Our Reference: SYD16/01626
Department Ref: SSD 8114

LINDFIELD LEARNING VILLAGE - 100 ETON ROAD, LINDFIELD

Roads and Maritime has reviewed the submitted application and does not support the development in its current form and provides the following comments for consideration:

Scale at A3

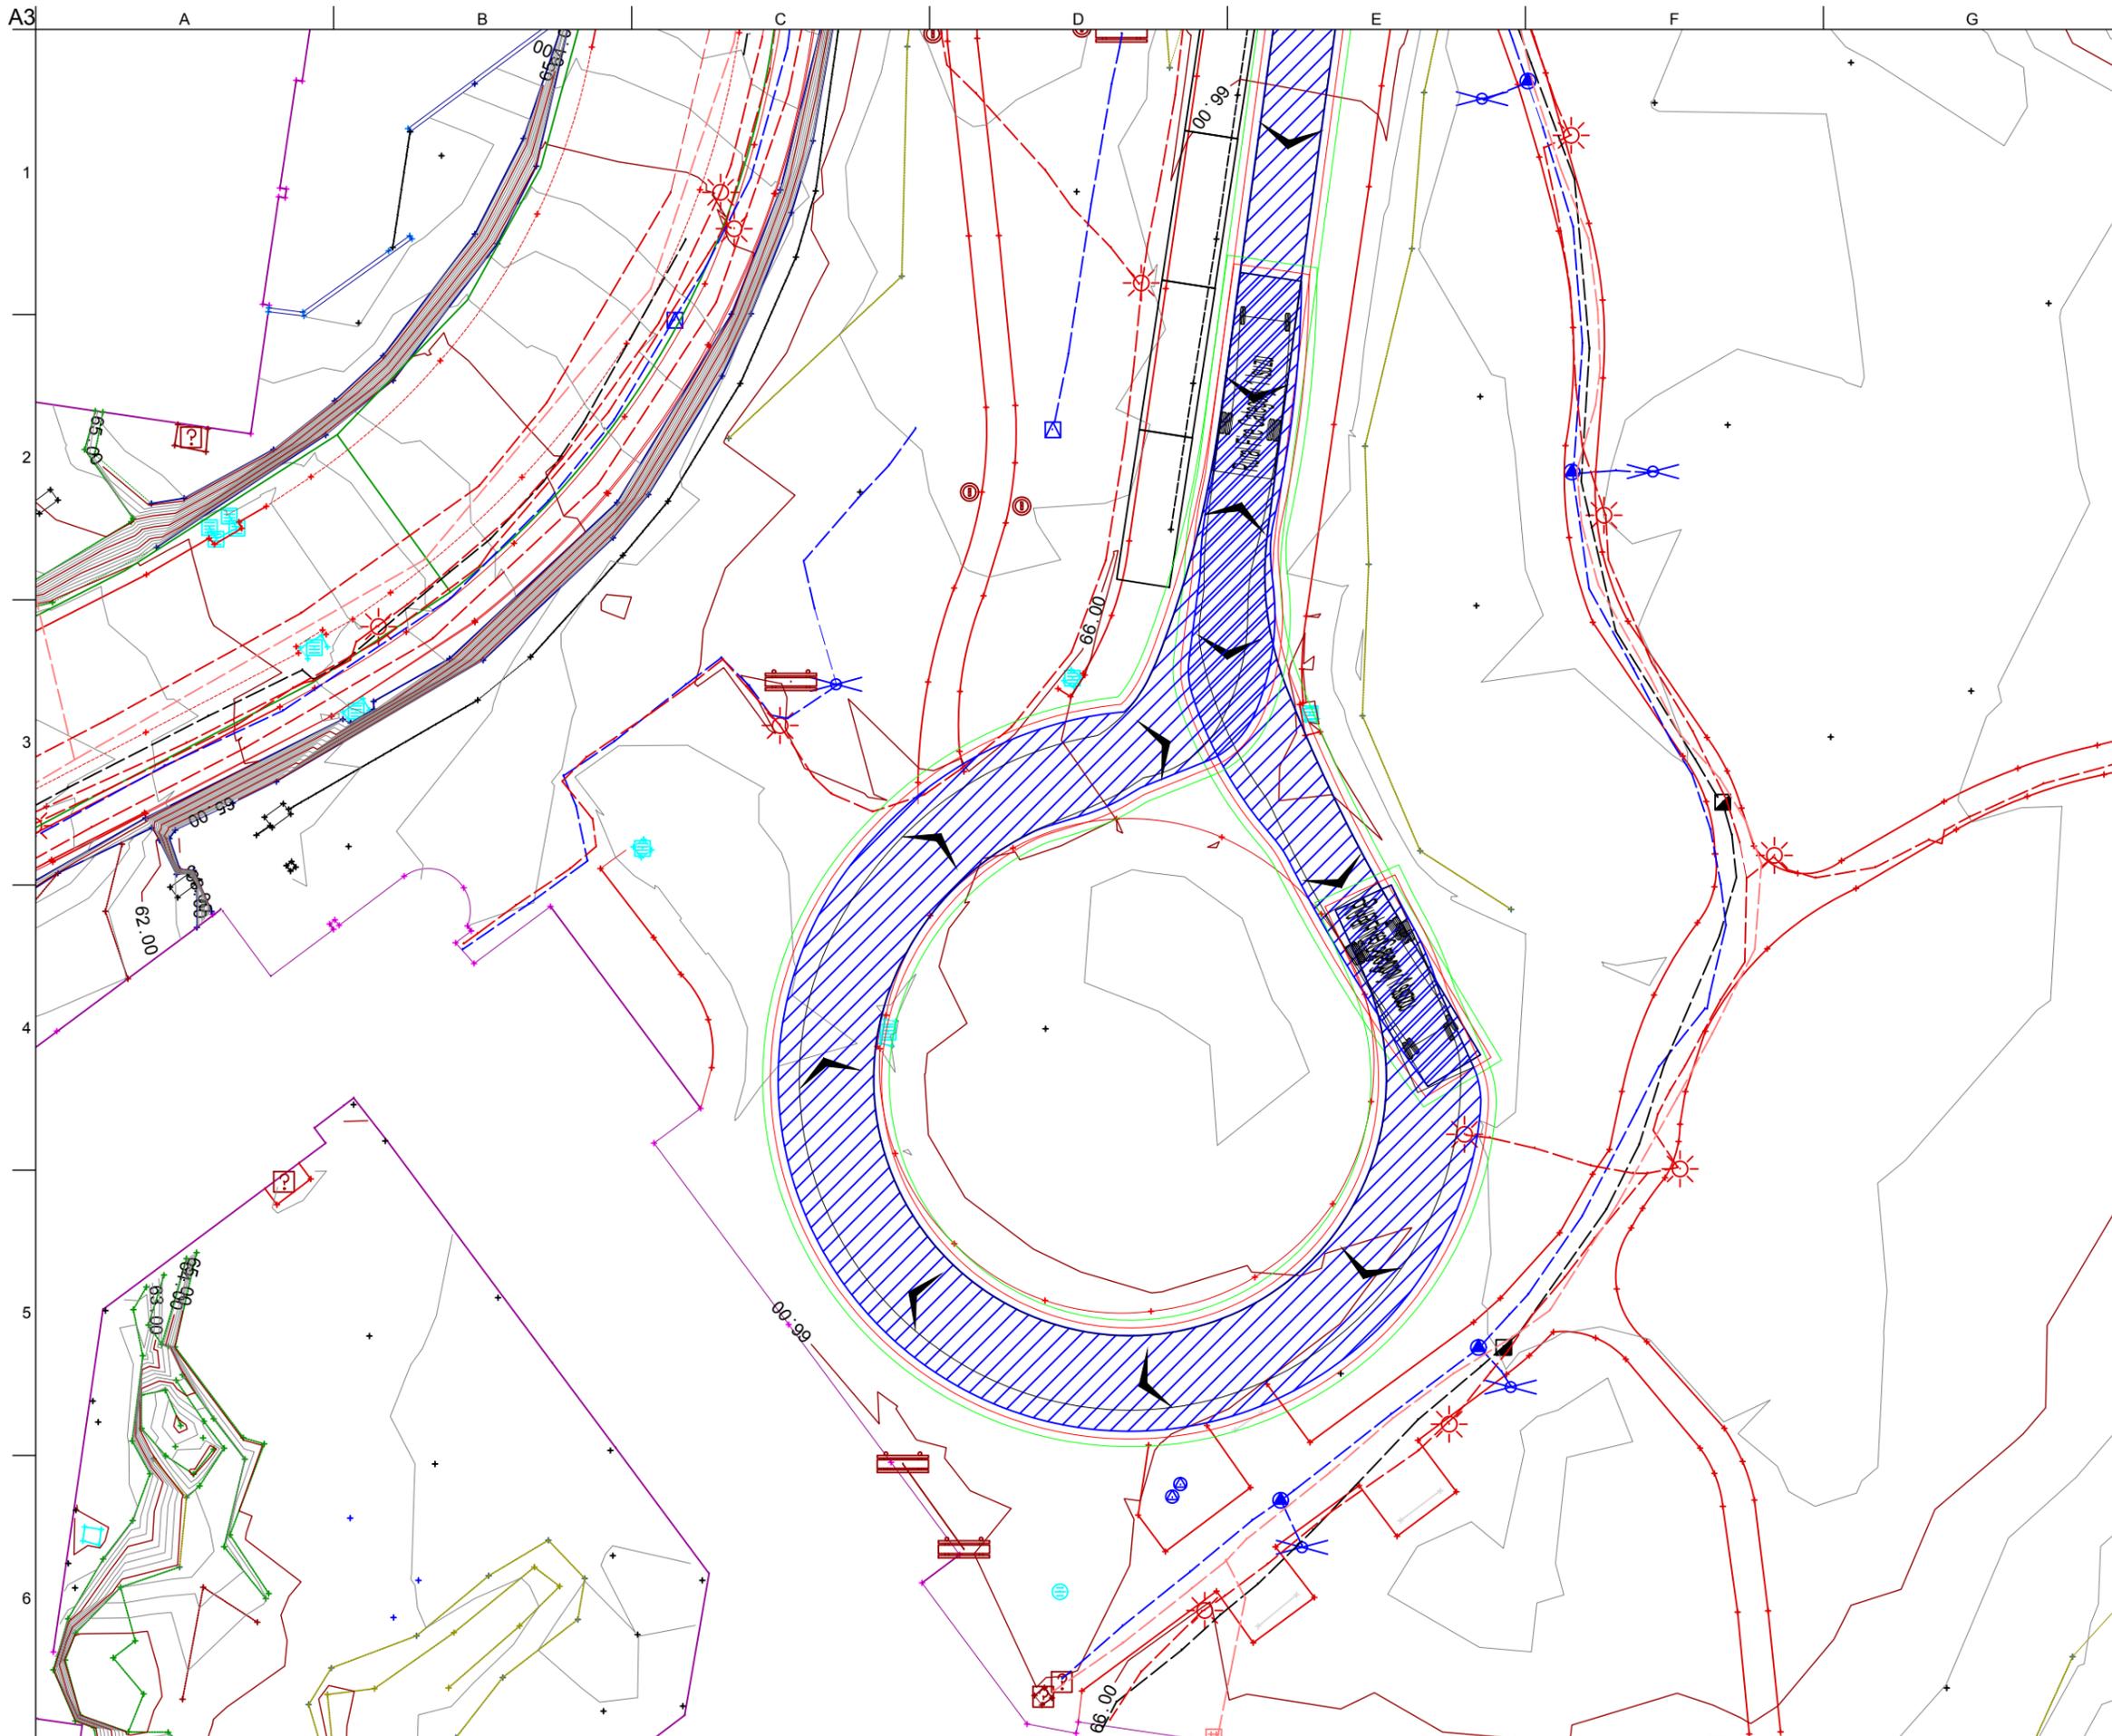
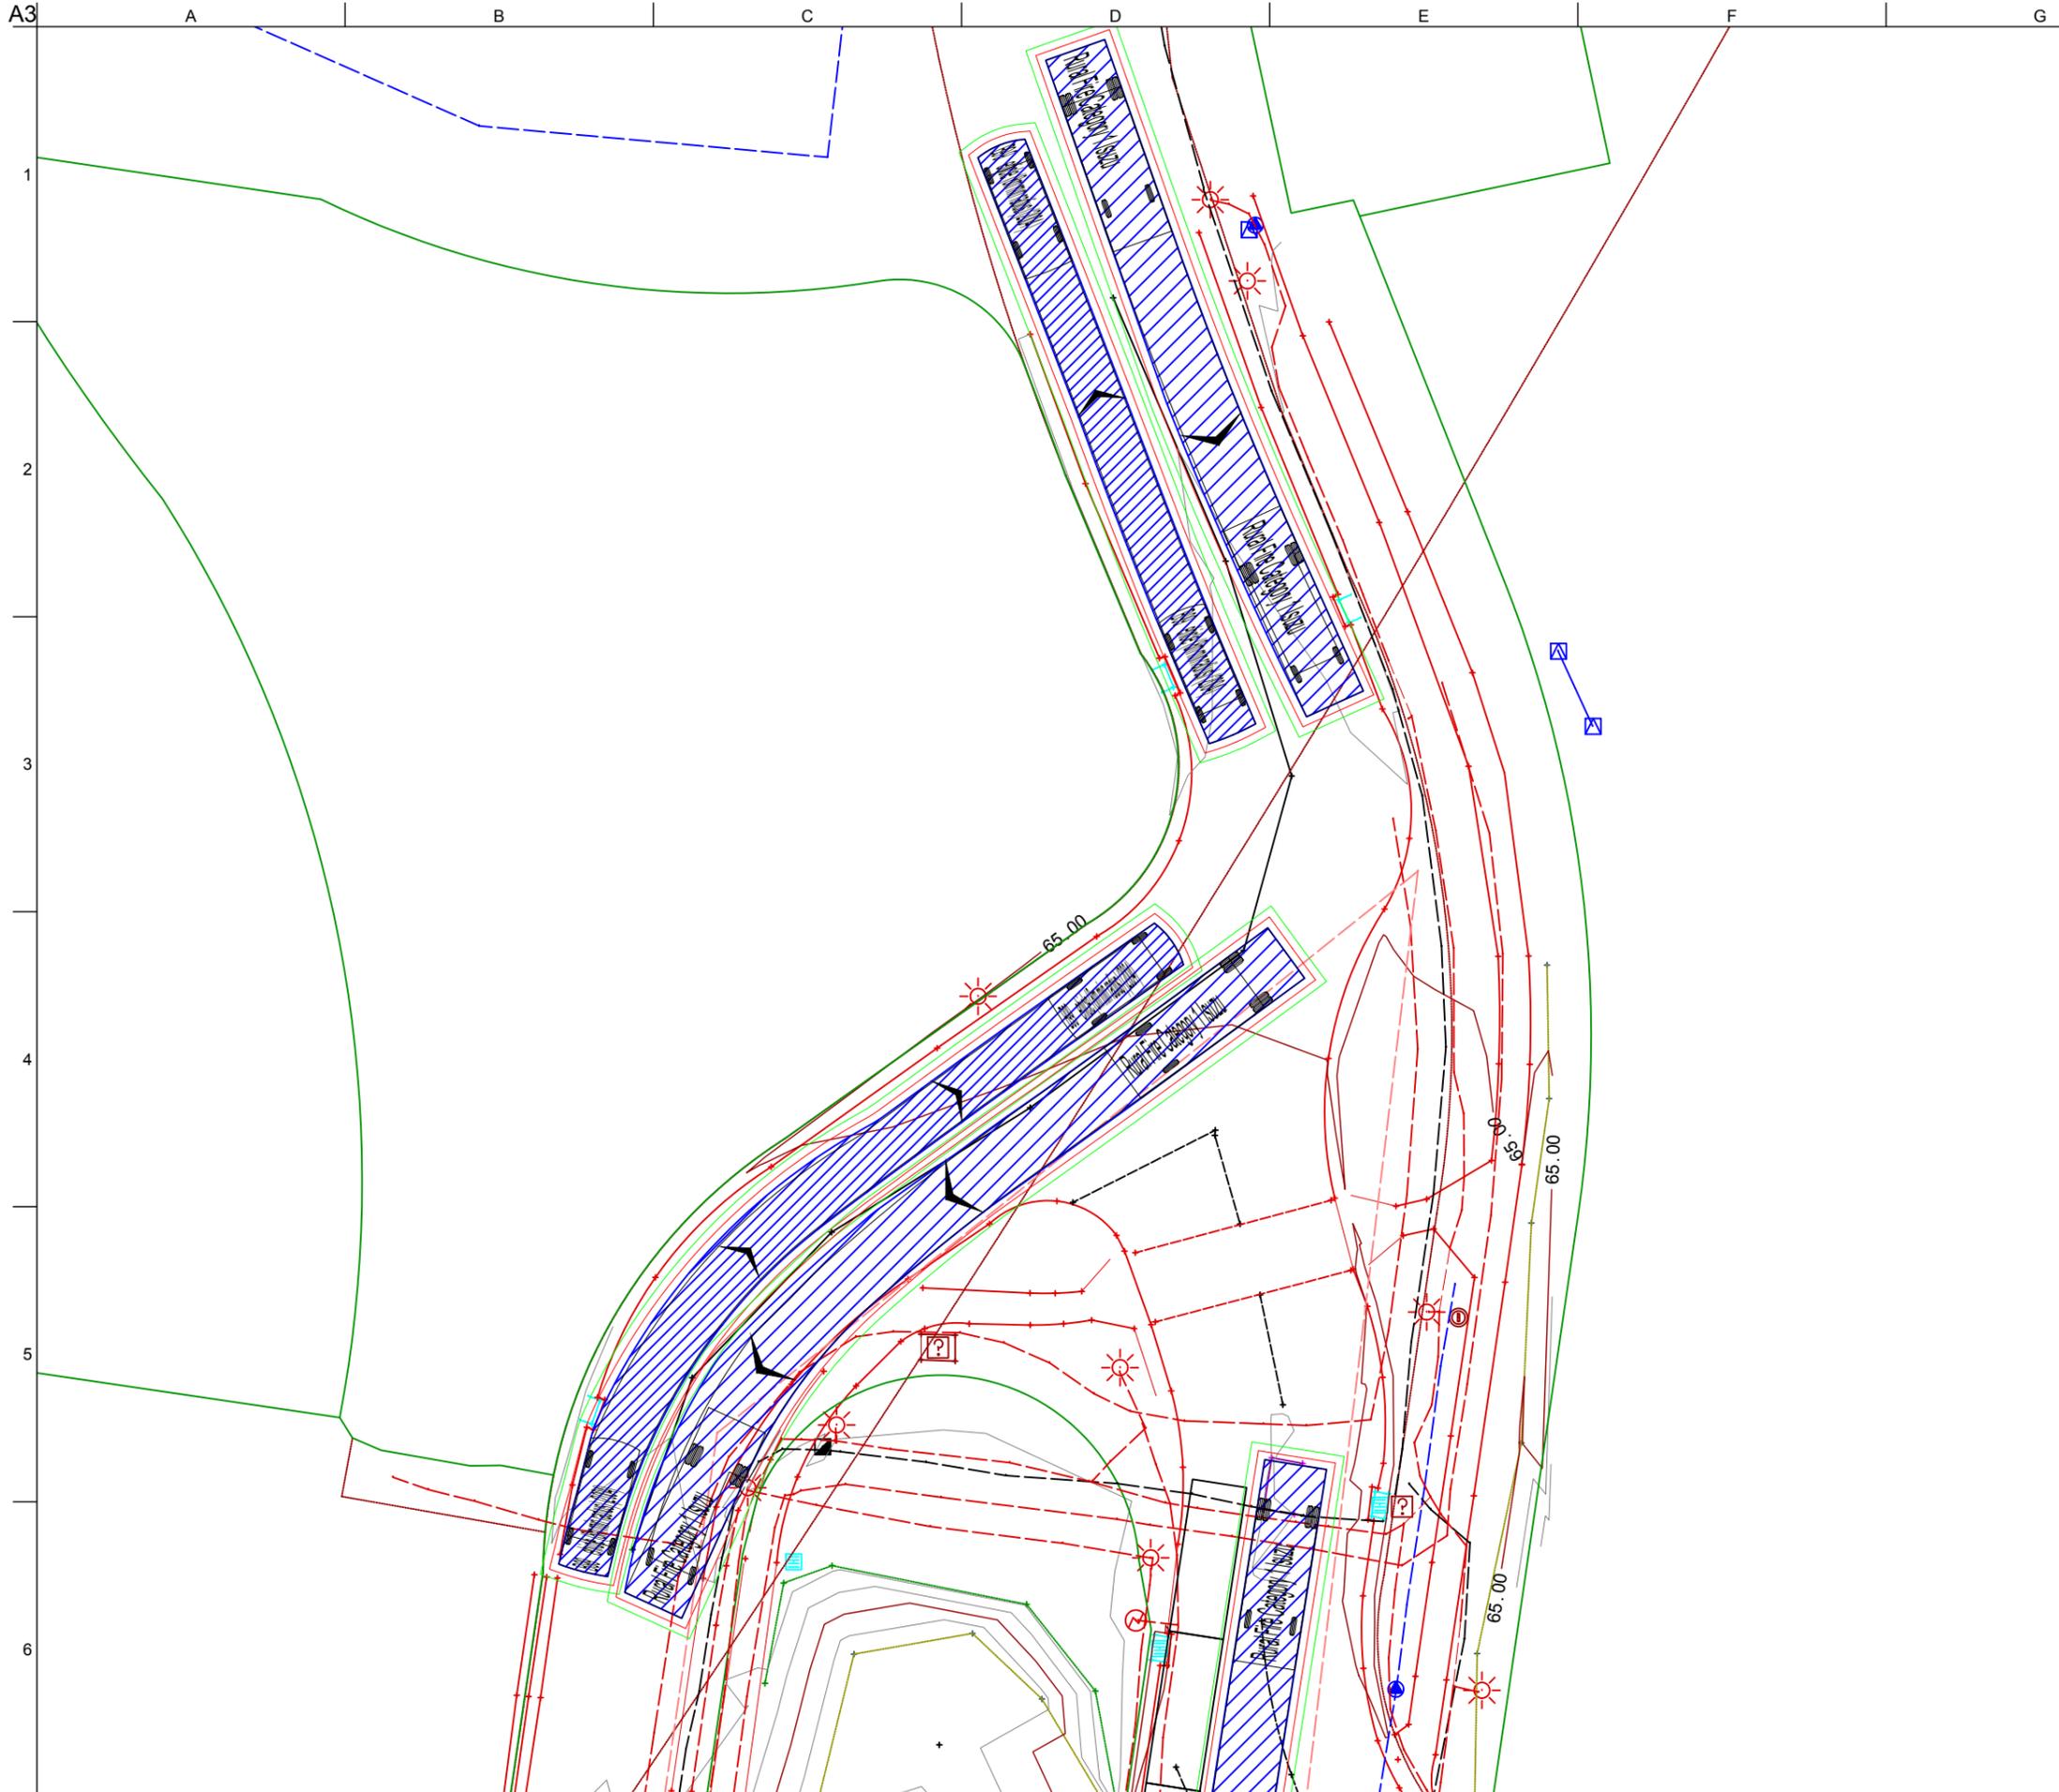
1. Given the narrow nature of the Eton Road access to the campus/school grounds, Roads and Maritime requires clarification regarding emergency vehicle access in emergencies.

Drawing Title  
**Turning Paths  
 12.5m buses**

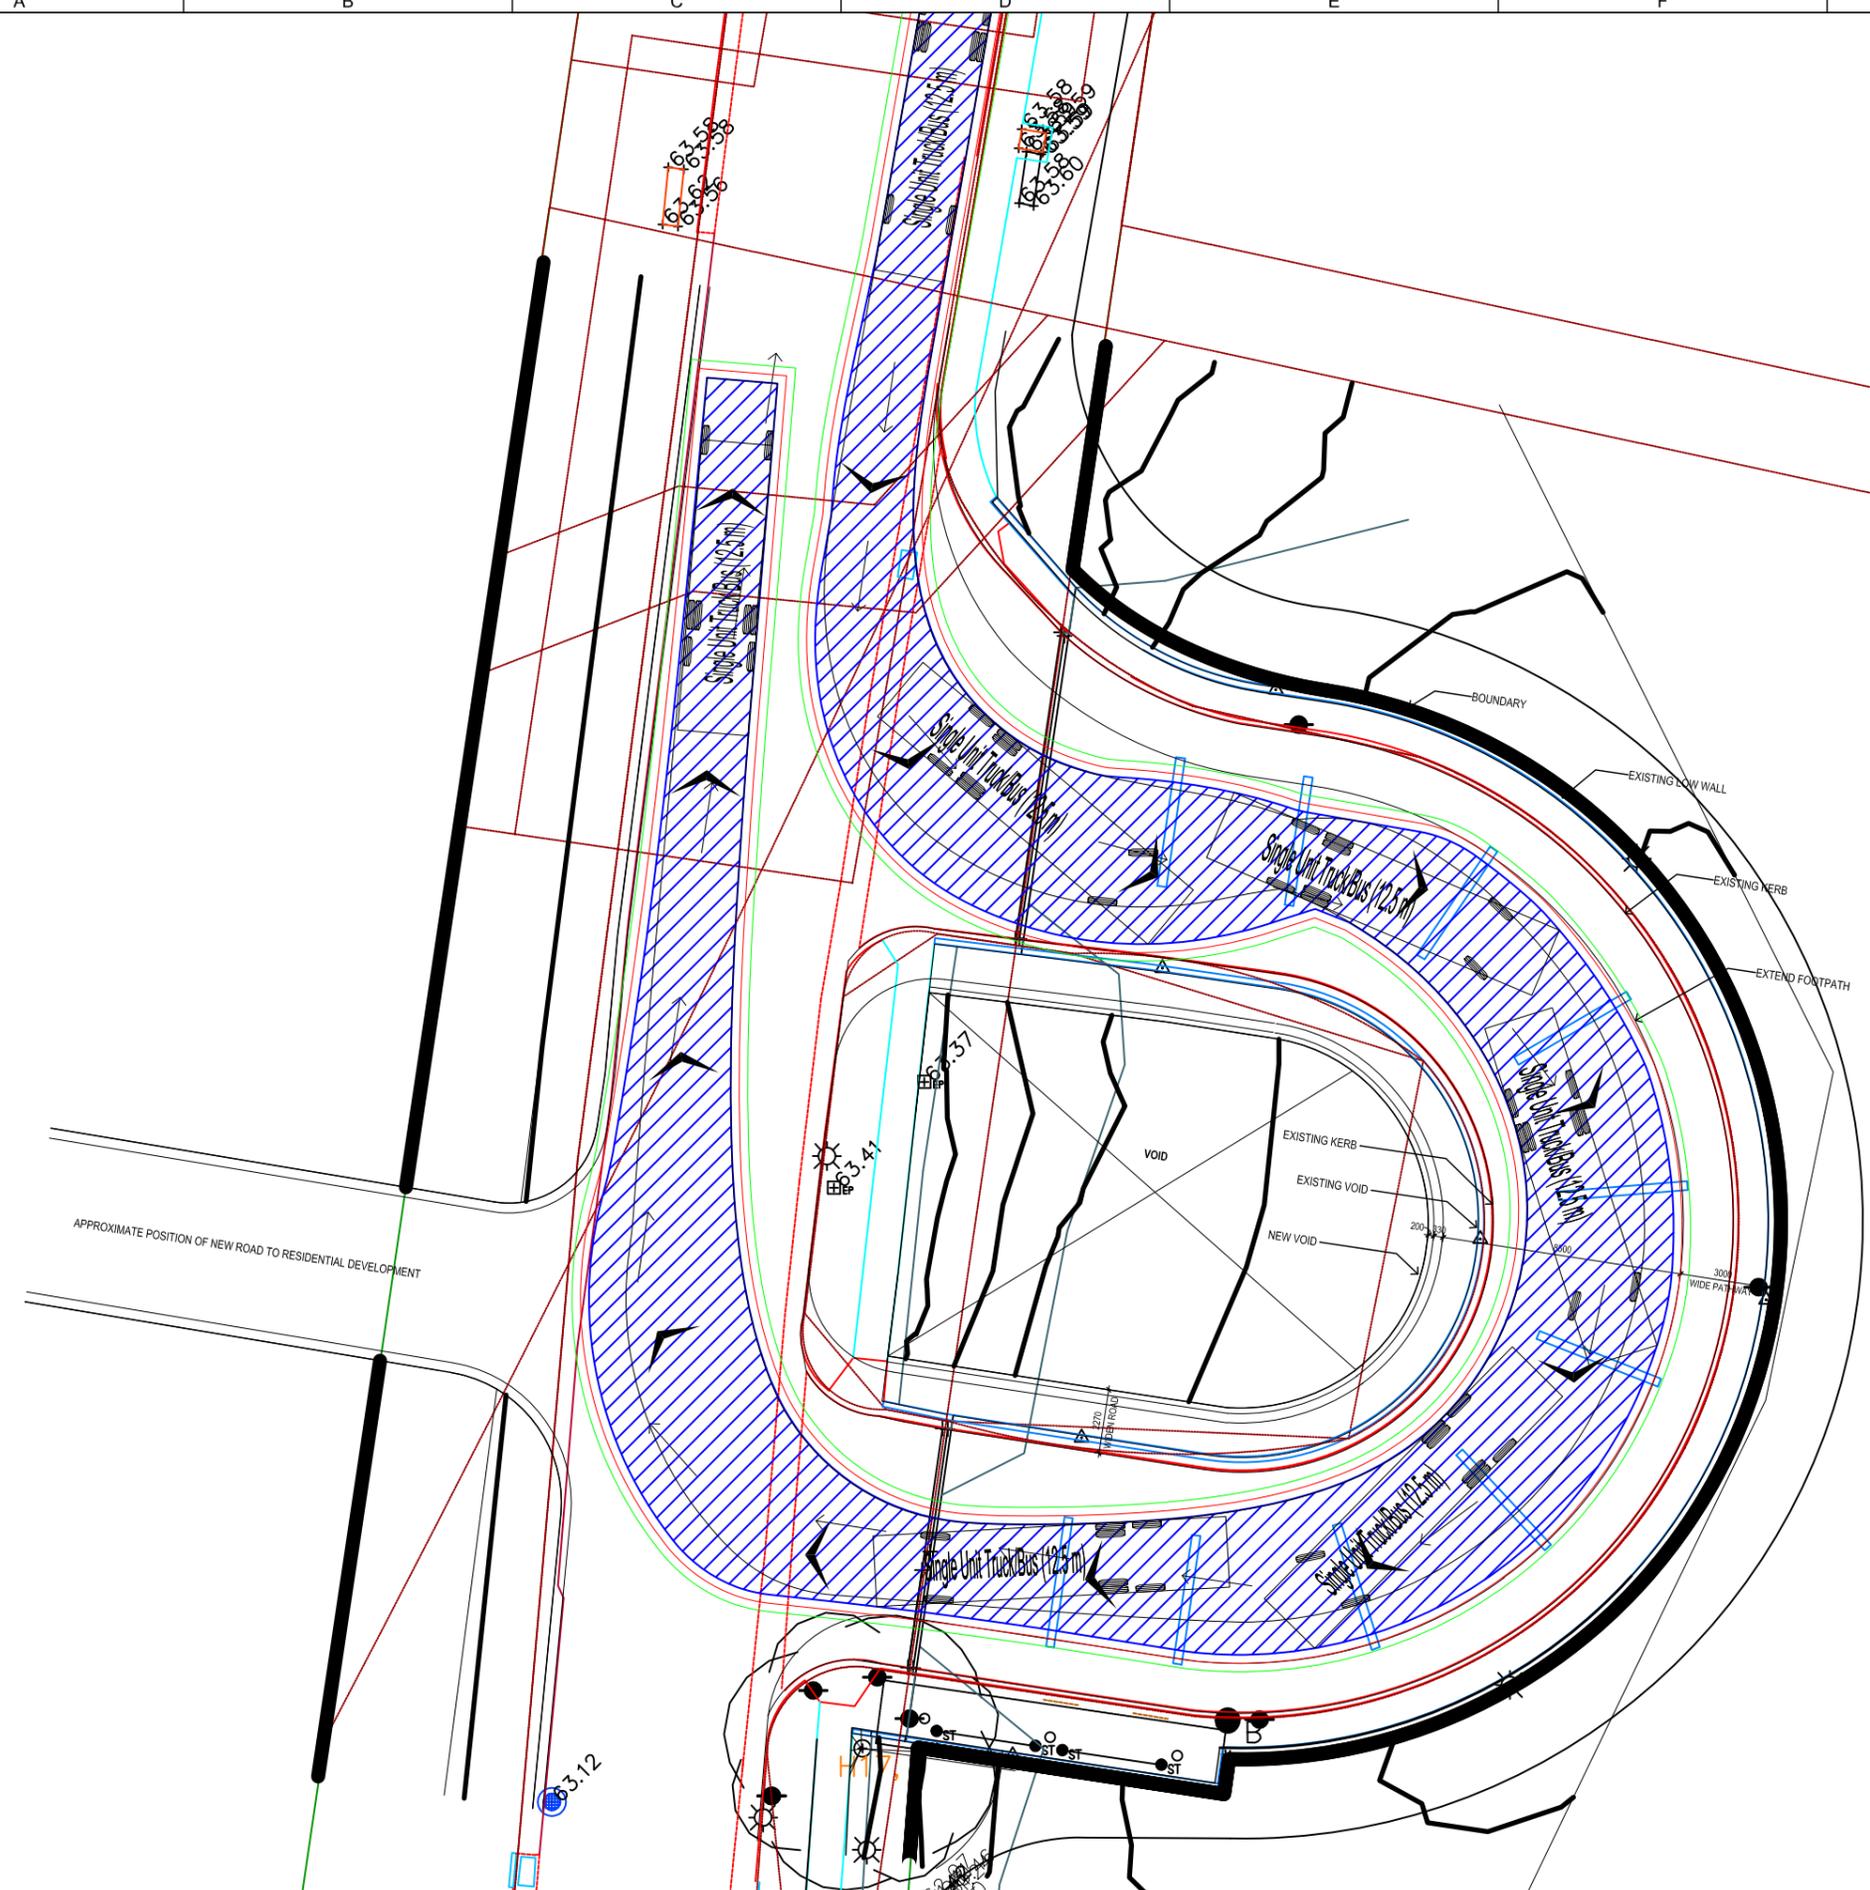
- Buses using the bus bay do not appear to have enough clearance to safely navigate the bus bay without rubbing up against concrete walls or pedestrian fences. The 600mm body clearance has not been achieved.
